Re: Construction Seminars - 4927 Prospect Ave NE; Bldg Permit # 201691091
Request for Certificate of Occupancy- Transportation Development
Architect's Stamp dated 08-04-16 (H17D112)
Certification dated 10-13-16

Project Title: Construction Seminars

Re: Construction Seminars Renovations
7915 Prospect Ave NE
Traffic Circulation Layout
Architect's Stamp 08-04-16 (H17D104)

Re: Construction Seminars Renovations
4915 Prospect Ave NE
Traffic Circulation Layout
Architect's Stamp 07-20-16 (H17D104)
12

A1 PROPOSED SITE PLAN  
SCALE: 1" = 20'-0"

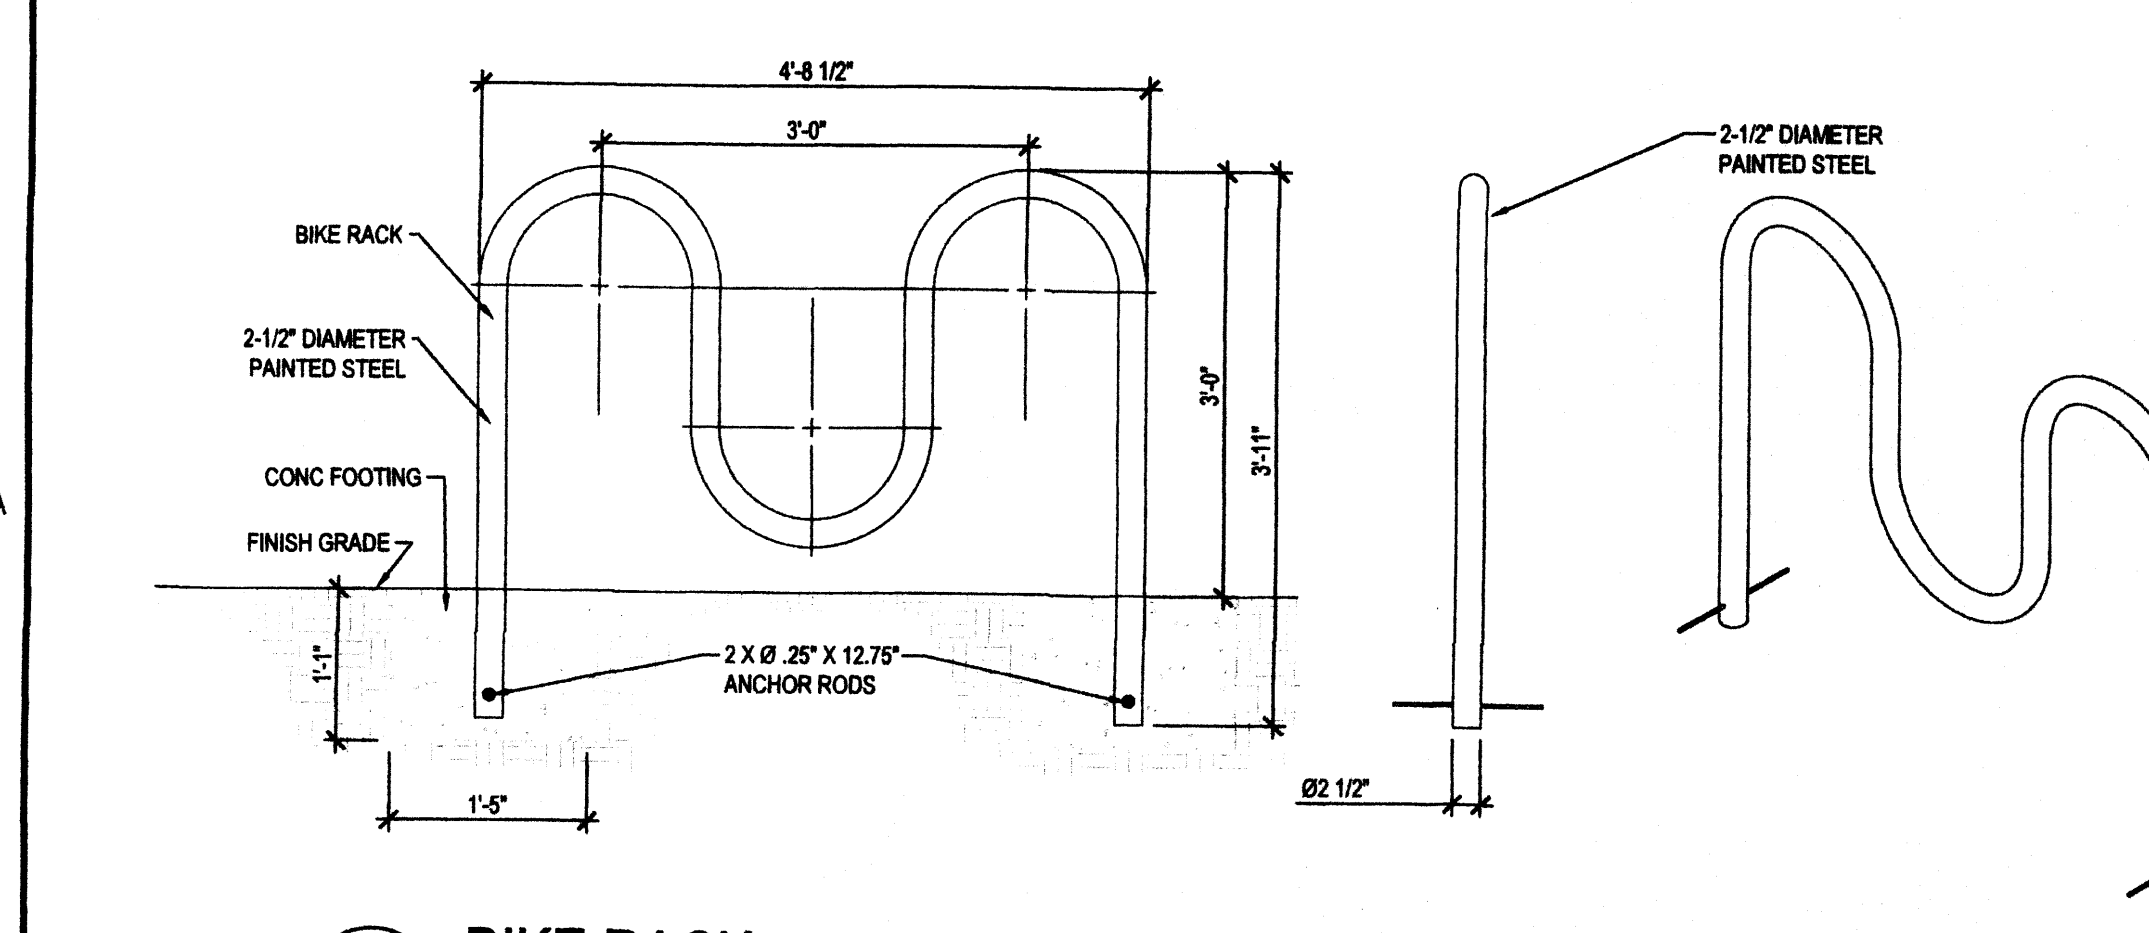
- ✓ 1. Please show a vicinity map showing the location of the development in relation to streets and well known landmarks.
- ✓ 2. Identify the right of way width, medians, curb cuts, and street widths on Prospect Ave NE.

- ✓ 3. The 6 ft. wide ADA accessible pedestrian pathway required from the public sidewalk to the building entrances must be clear of any curb lines. Please clearly show this pathway and provide details.

- ✓ 4. Provide a detail of all ADA accessible ramps onsite.
- ✓ 5. Provide dimensions of motorcycle parking. (Zoning Code, 14-16-31, C.)
- ✓ 6. One-way vehicular paths require pavement directional signage and a posted "Do Not Enter" sign at the point of egress. Please show detail and location of posted signs.

- ✓ 7. Please provide a sight distance exhibit (see the *Development Process Manual, Chapter 23, Section 6, Part B.12 Visibility for Driveways*).
- ✓ 8. Please add the following note to the clear sight triangle: "Landscaping and signage will not interfere with clear sight requirements. Therefore, signs, walls, trees, and shrubbery between 3 and 8 feet tall (as measured from the gutter pan) will not be acceptable in this area."

- ✓ 9. Please specify the City Standard Drawing Number when applicable.
- ✓ 10. Add keynote 11 to all overhead garage doors.
- ✓ 11. Provide conformation from zoning the amount of parking required and provided is correct. Does not need AA approval per previous site plan

- ✓ 12. Clarify the limits of the portal that covers the front walkway.

- ✓ 13. Show the existing property lines.
14. Please add a note on the plan stating "All improvements located in the Right of Way must be included on the work order."

- ✓ 15. Show the 3 curbside parking spaces called out on the parking total requirements. If On-street parking credit is required please follow item to request On-Street parking.

- ✓ 16. On-Street parking Allowance to fulfill zoning's parking requirement must be requested and approved by the Traffic Engineer, Racquel Michel prior to TCL approval. The application requires at least 30 working days. On-street parking allowances are based on available parking along public right-of-ways fronting the property. The business will only be granted 50% credit for available street parking.

- ✓ 17. Add a note stating "All broken or cracked sidewalk must be replaced with sidewalk and curb & gutter." A build note must be provided referring to the appropriate City Standard drawing.
